# CITY OF PORTLAND

Job ID: 2012-02-3267-ALTR

has permission to Interior Remodel kitchen and Bath

## Jonathan Rioux - 168 Grant Street

- Duplex -

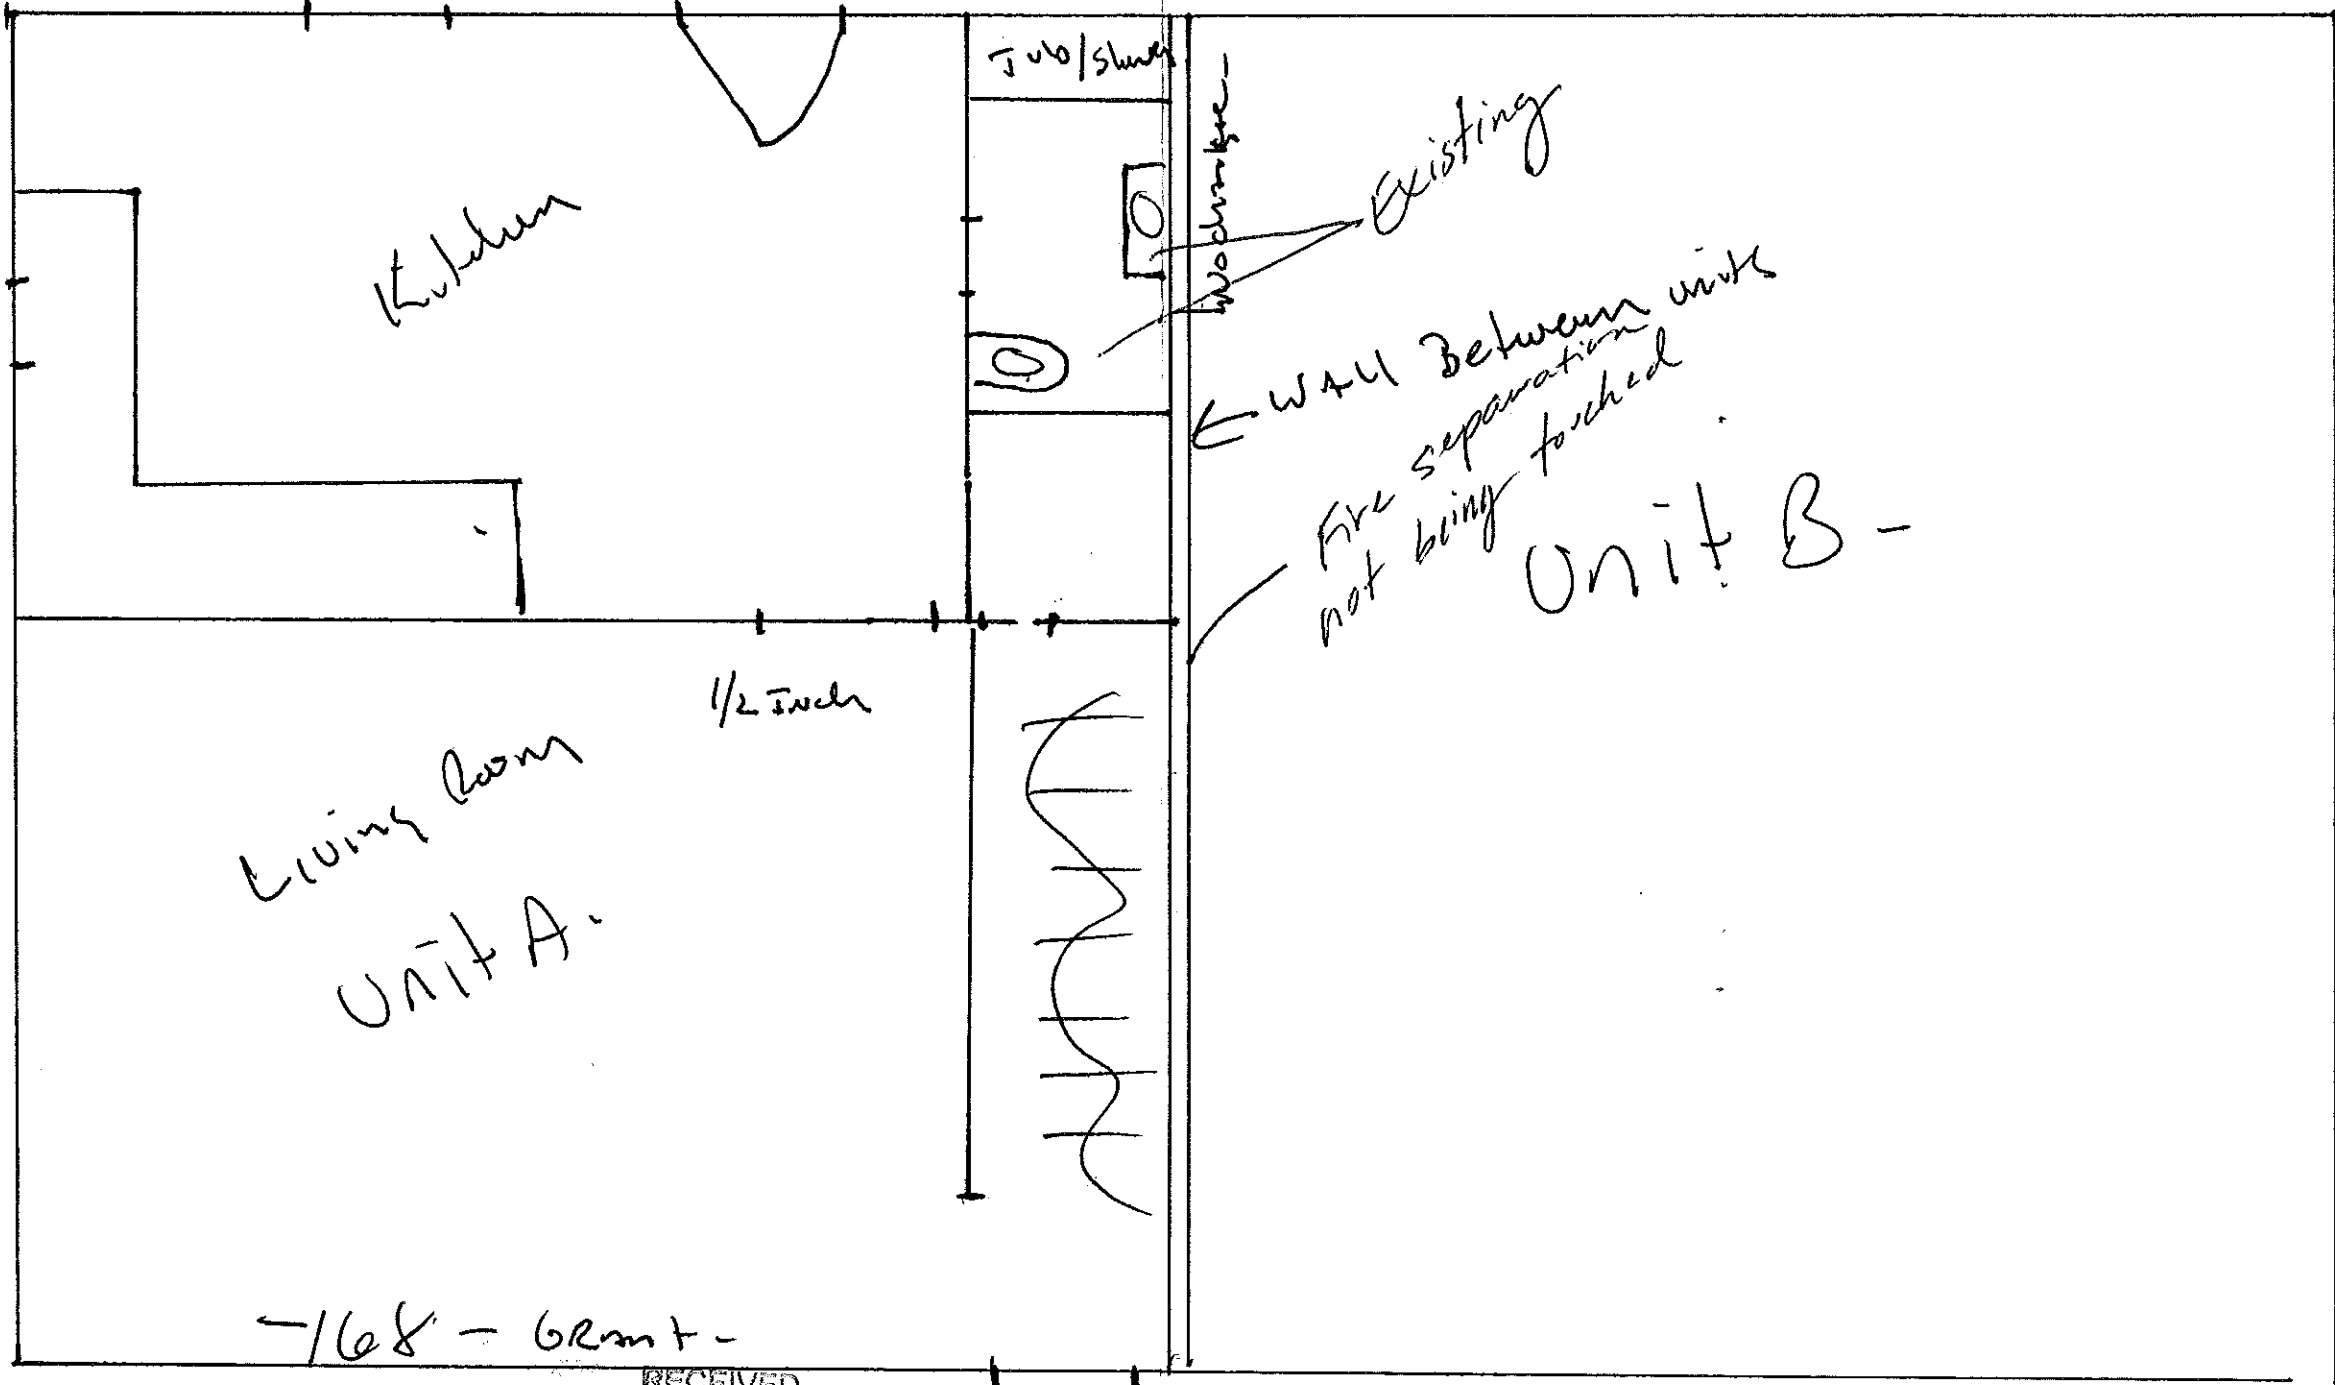
- Are you affecting the two unit separation?
- What section(s) are actually being framed vs existing, cross-section needed?
- What is the finish headroom of all areas?
- Bathroom fixture clearances?
- New windows, heights from grade, header sizing/ spans?
- What floor is the renovations on?
- What are you insulating with?
- Are all the doorways existing?

1. We are not tearing into the other unit...The bathroom wall separate the two units.
2. We would re frame interior walls to make plumb for new kitchen cabinets as well as sheetrock.
3. Finish headroom will be 95"...
4. Between the toilet and sink 30" between tub and toilet 40" all units will go back in the same place.
5. All renovations are done on the first floor
6. R-19 will be used...on exterior walls..
7. No changes to the doorways...
